CITY OF ALBUQUERQUE

**Re: Preliminary Hydraulic Analysis for Mirehaven Arroyo Crossing
Engineer's Stamp Date (none), H19/D013**

MIREHAVEN CROSSING STRUCTURE
FIGURE 1

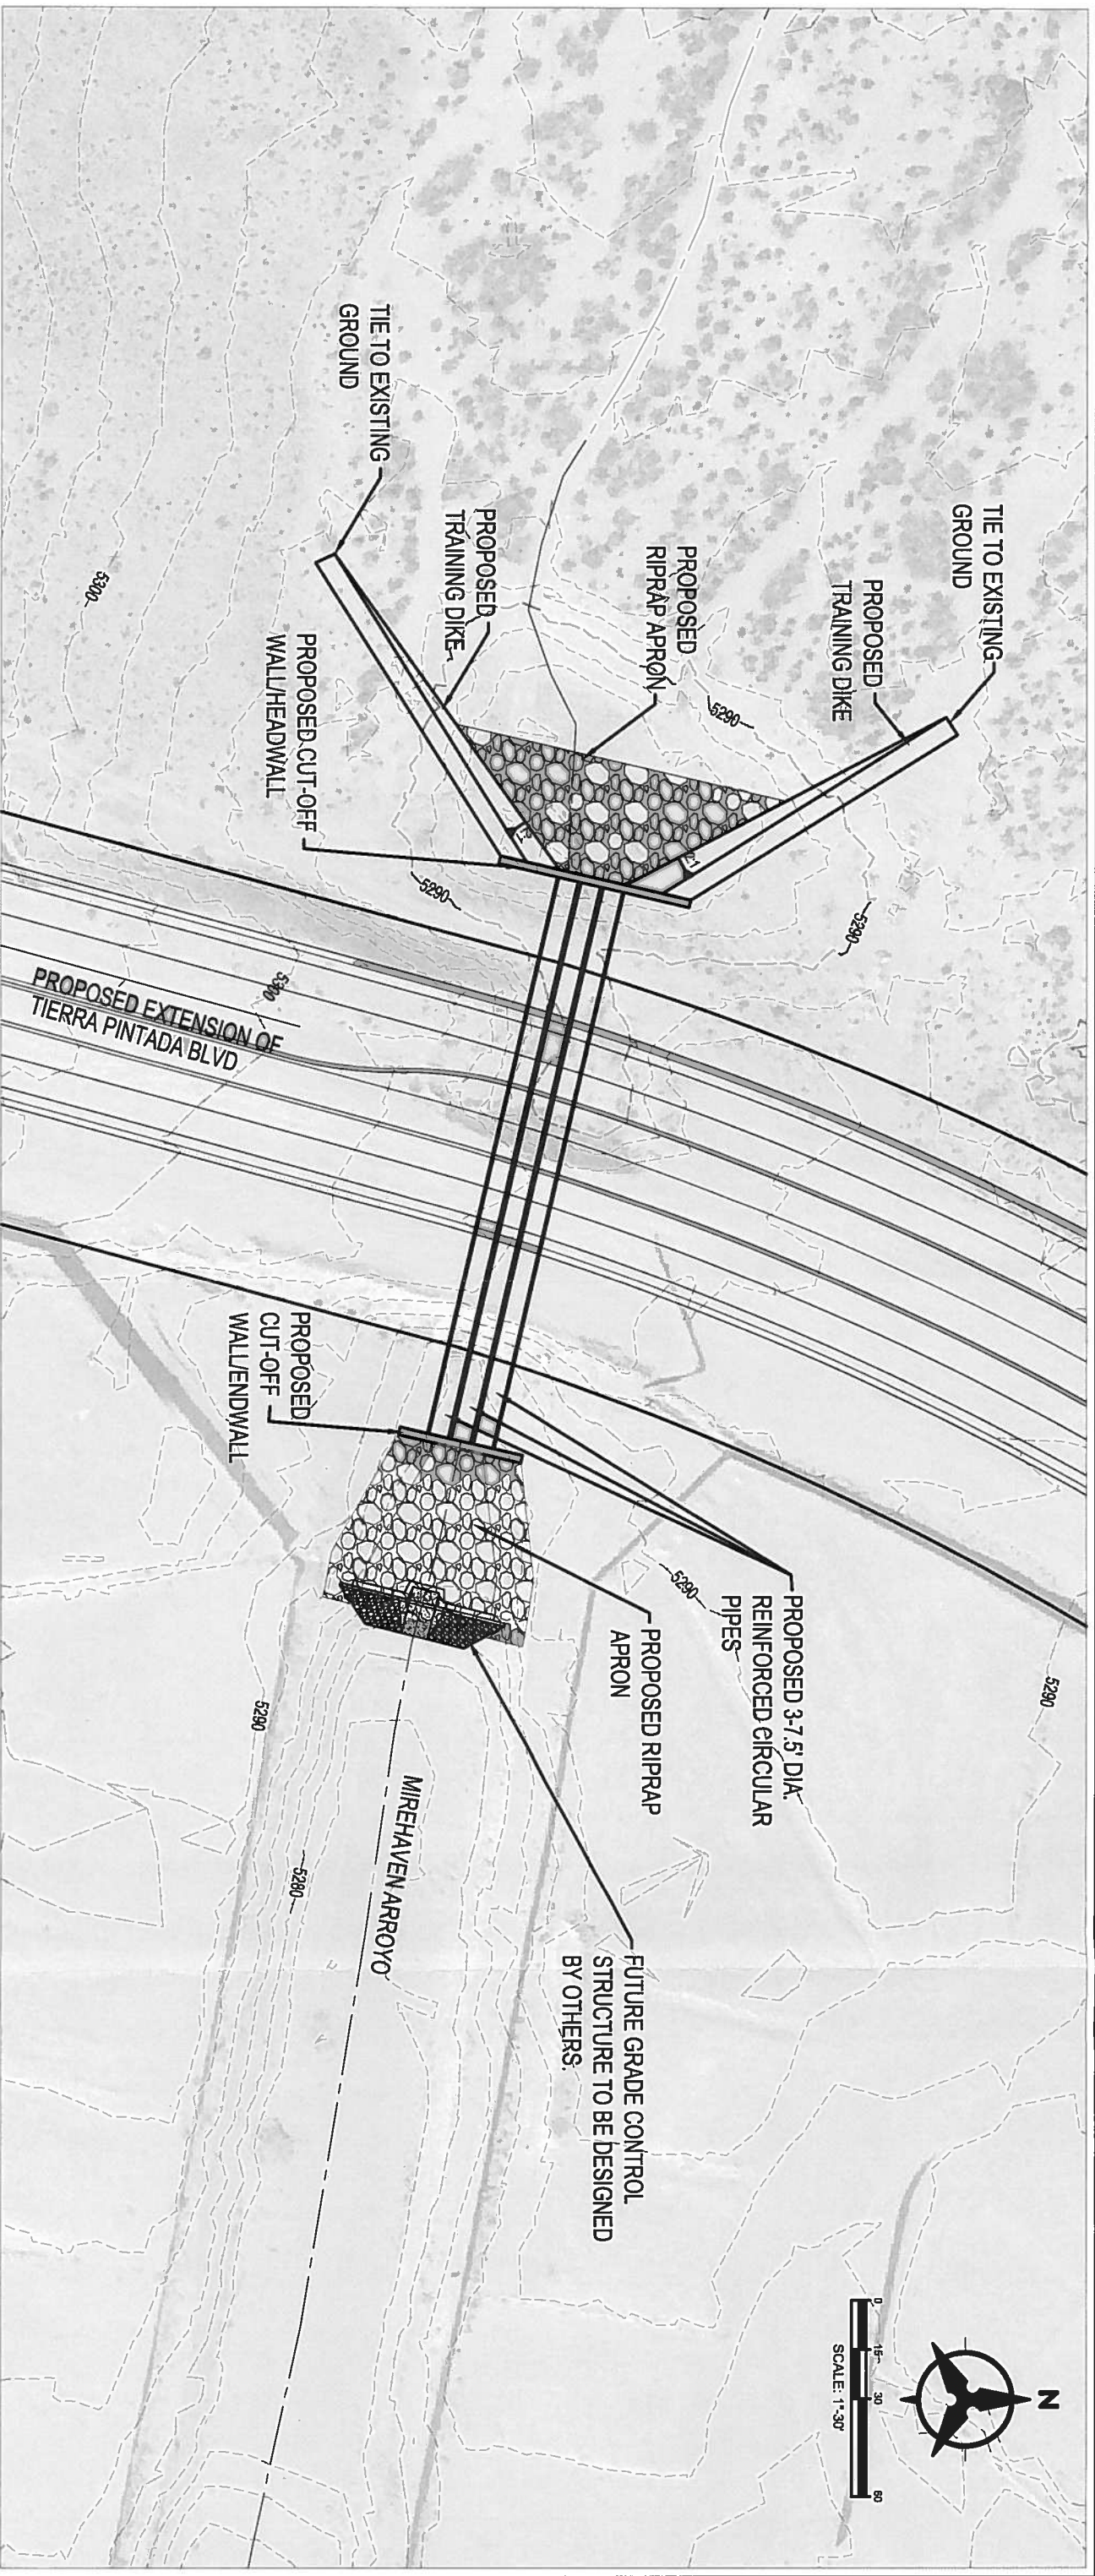
- A retention pond has been shown (requested by AMAFCA) upstream of the proposed culvert on the previously submitted plans to the City of Albuquerque.
- How will the culvert crossings impact the existing graded channel to the east? Mirehaven channel was graded as part of the Storm Cloud Phases IV and V, and there are neither slope protections nor drop structures along the channel.
